KITTITAS COUNTY

MEMORANDUM

TO: All Staff
FROM: Public Works Plan Review Team
DATE: March 9, 2022
SUBJECT: BL-22-00006 Ritchie

The Public Works Department has reviewed the Request for Boundary Line Adjustment Application.

RITCHIE PROPERTY

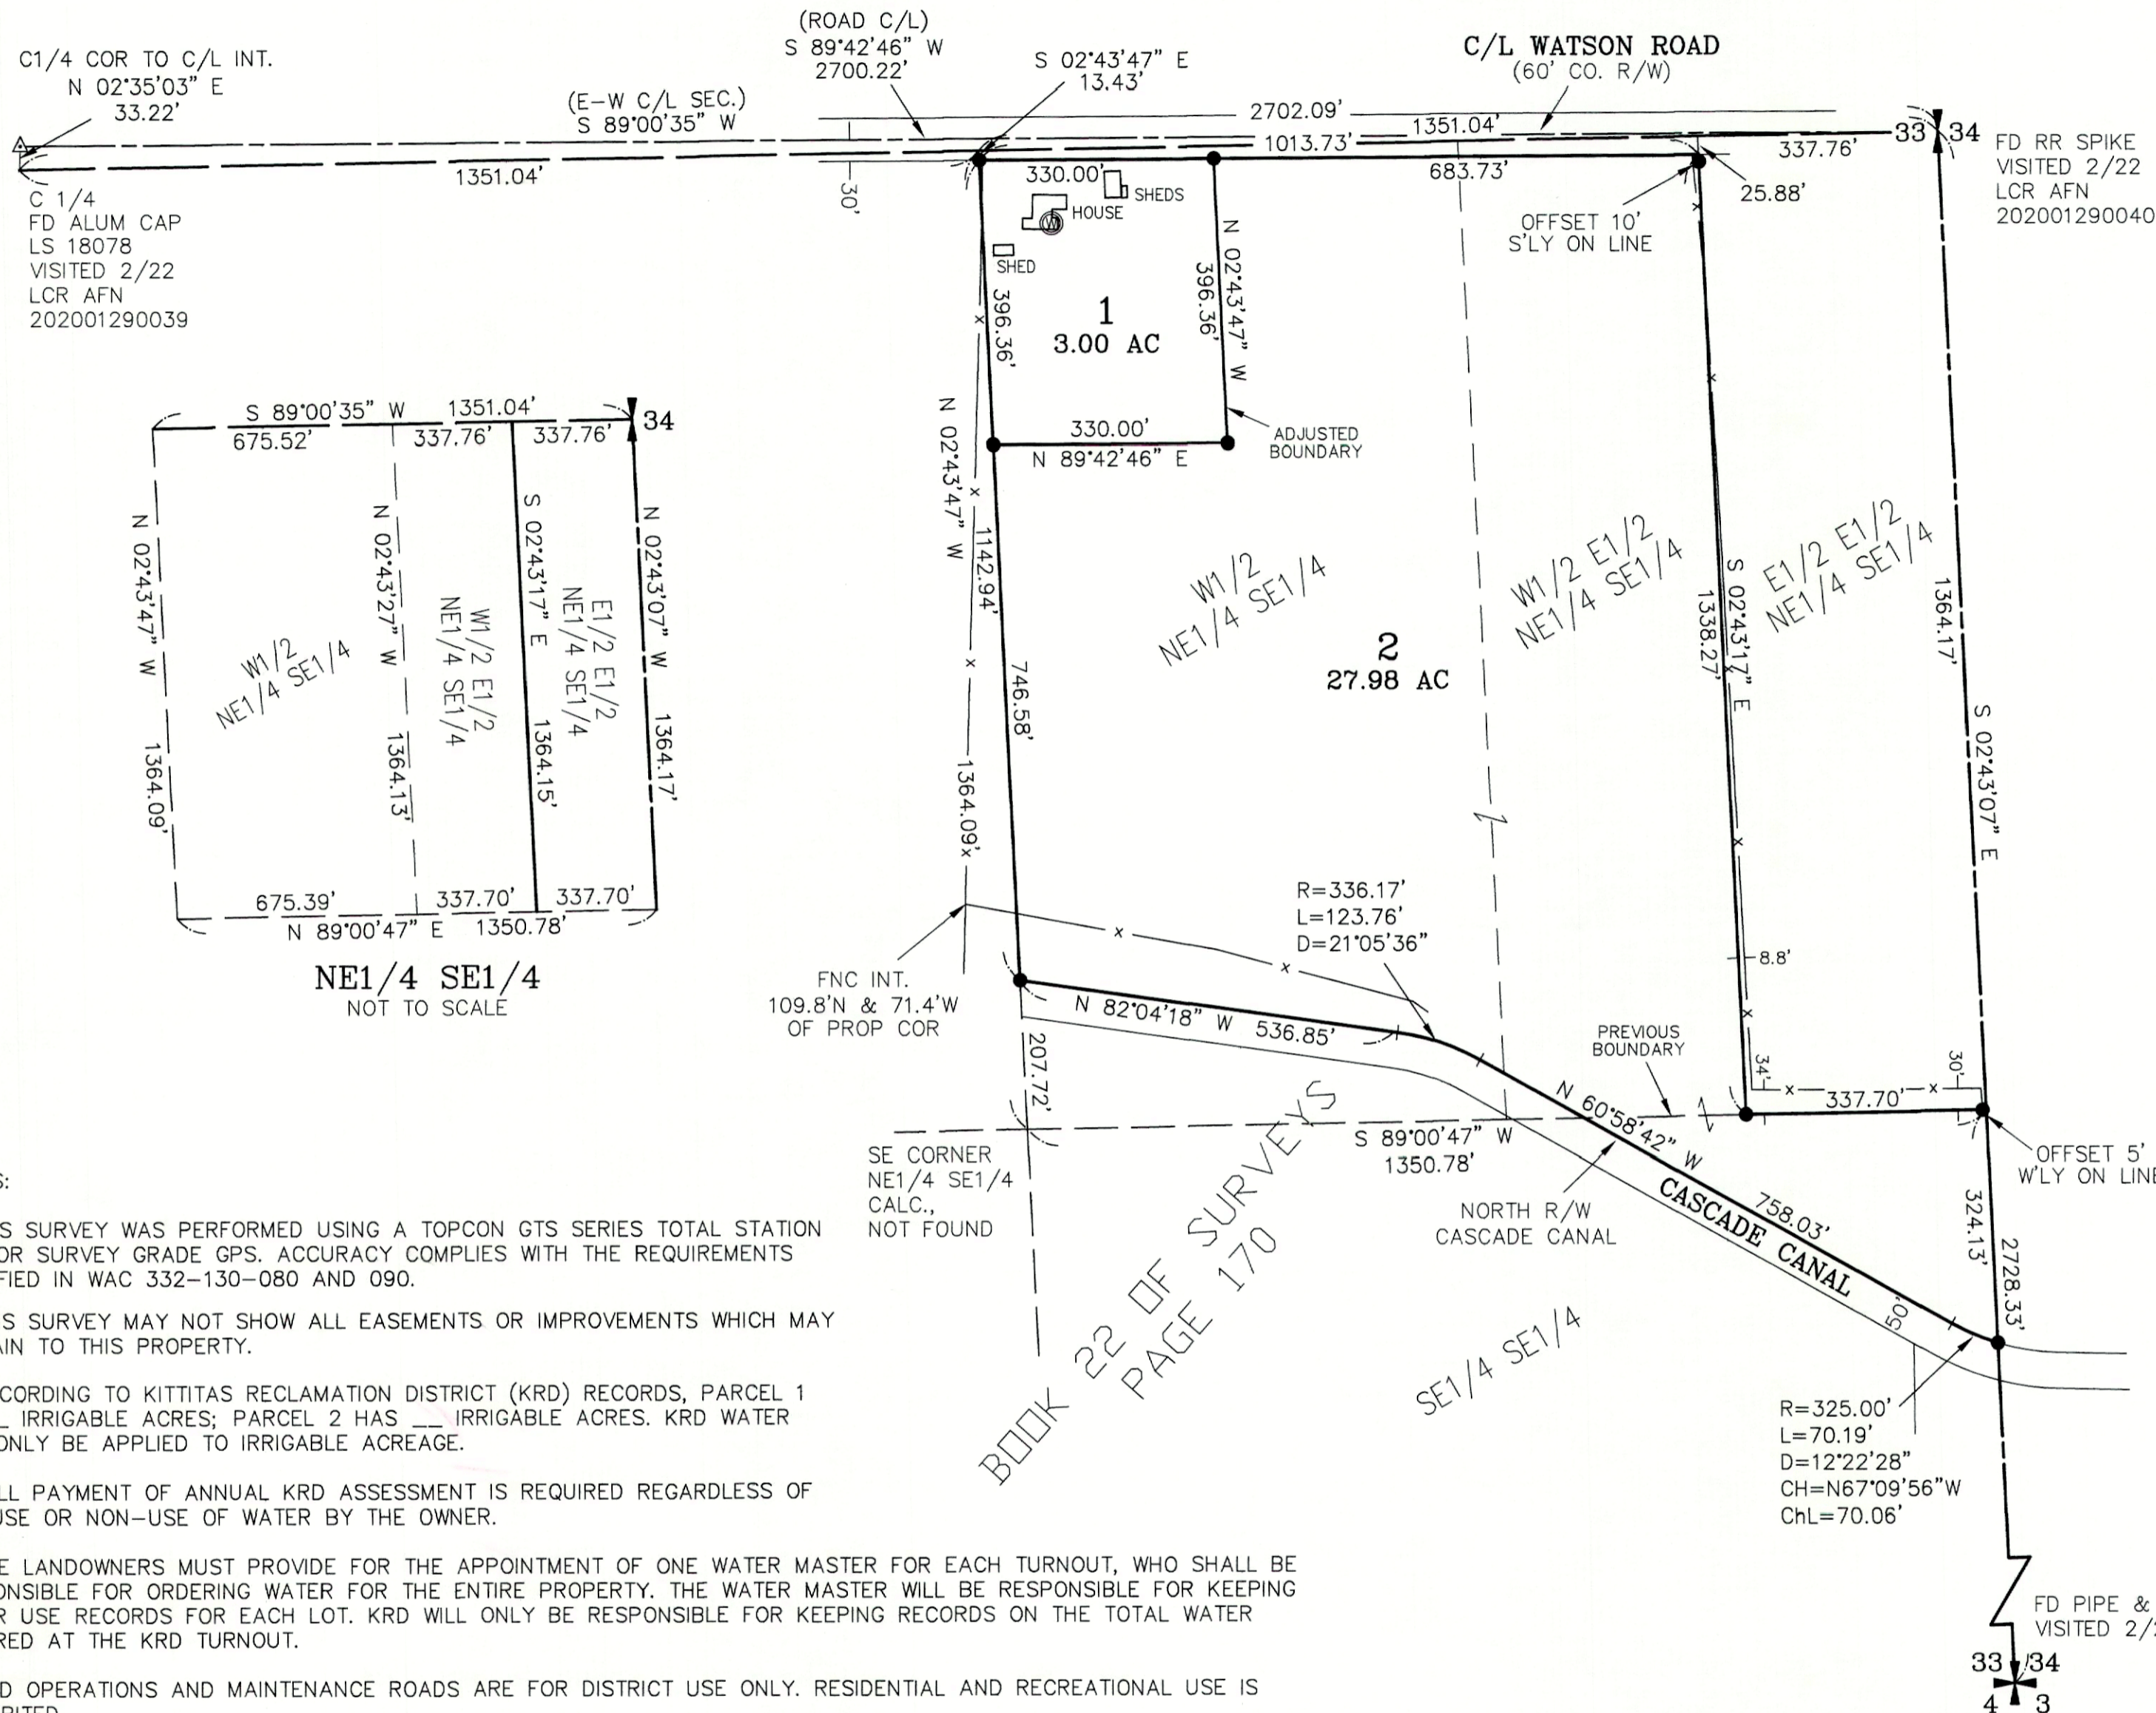
1. Application meets requirements according to KCC 16.10.020.
2. Additional comments are reserved for final.
